From: Ian.Gledhill@westsussex.gov.uk
Sent: 09 October 2012 17:22
To: Planningecons
Subject: Planning Consultation on: LU/146/12/

APPLICATION NO: LU/146/12/

Site Address: 12 St. Catherines Road Littlehampton West Sussex BN17 5HS

Description of Works: Proposed conversion of existing vacant dwelling into 6 no. self contained residential units

Site Plan. Scale 1:200

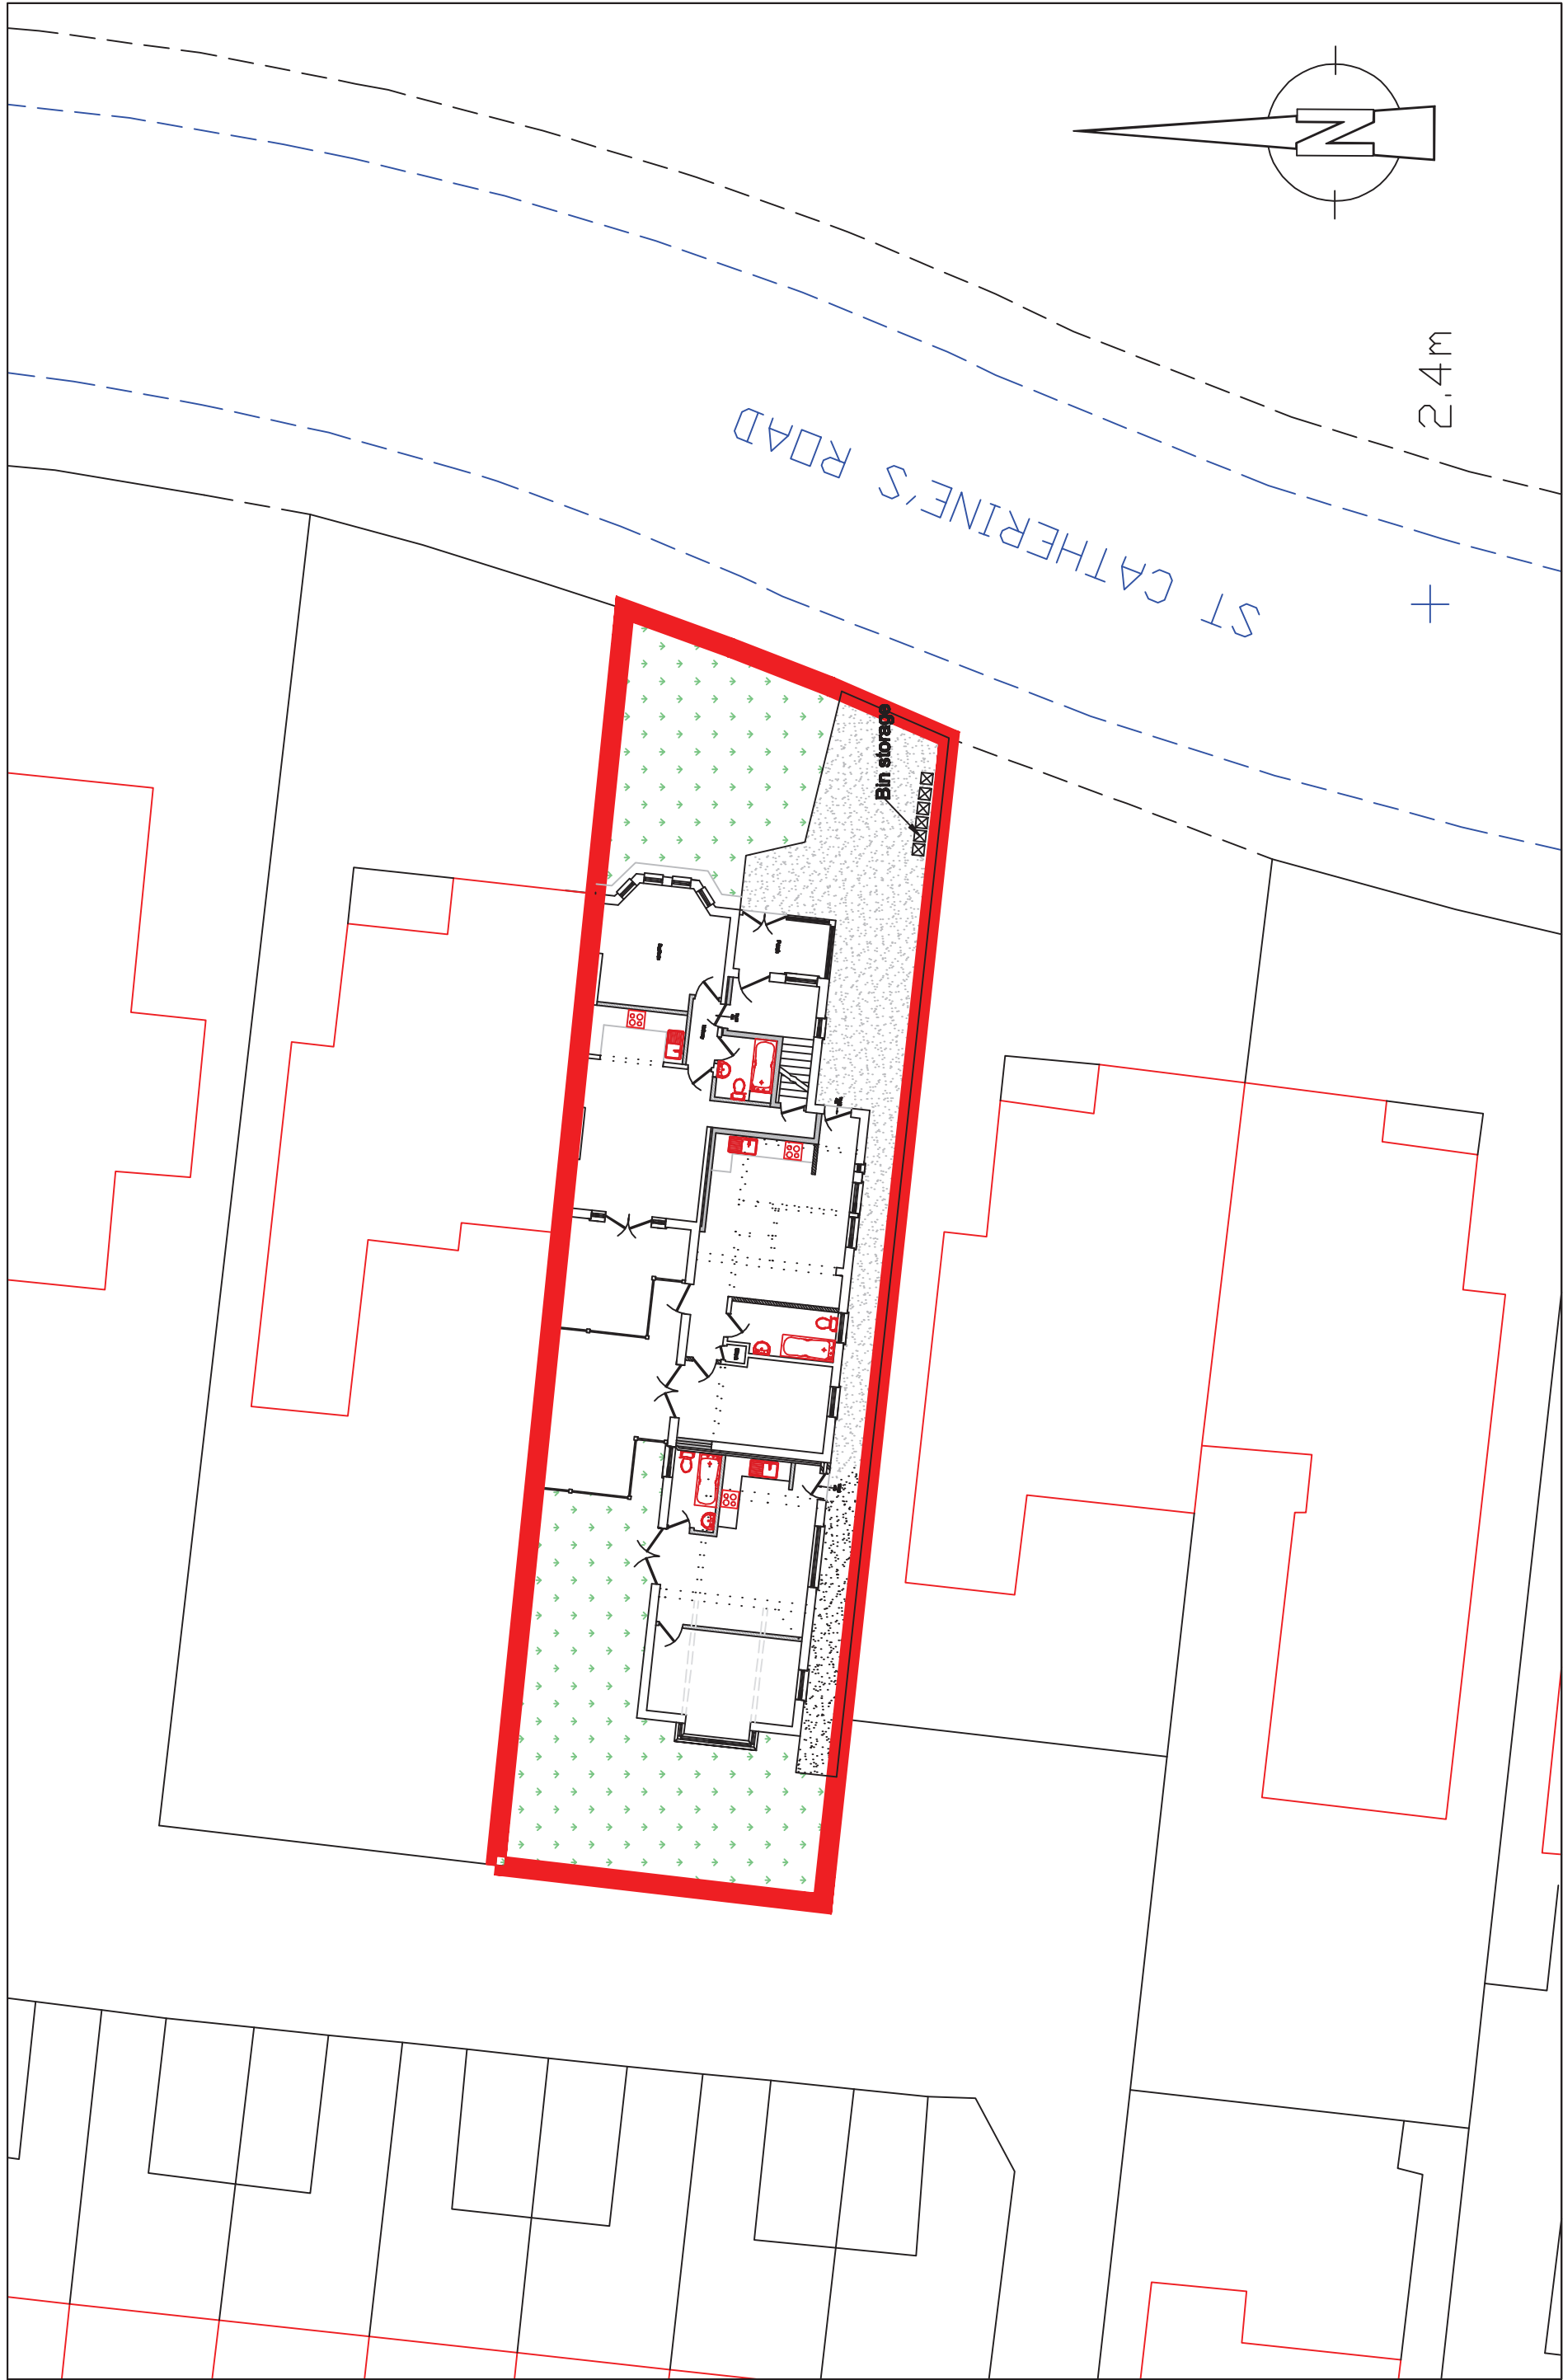
The submitted information does indicate that the existing building was formerly used as a residential care home, although it's unclear exactly when this use ceased. Nevertheless, some consideration does need to be given to the potential traffic generation and parking demands associated with this permitted use, with these viewed against the potential demands generated by the proposed scheme. In terms of vehicle movements, the proposed scheme would generate an immaterial increase, thus no concerns would be raised. The WSCC Parking Demand Calculator does identify that the proposed flats would generate the demand for up to 5 parking spaces and it is noted that no parking is proposed on site, although the site does have an existing vehicular access. Discounting any potential parking that could arise from the permitted use were this to restart, whilst this proposal could give rise to additional on-street parking demands, which the Planning Authority may wish to consider, although the increased demand for 5 spaces is not anticipated to generate any highway safety concerns.

Details of the cycle parking provision should be secured via condition.

No part of the development shall be first occupied until covered and secure cycle parking spaces have been provided in accordance with plans and details submitted to and approved by the Local Planning Authority.
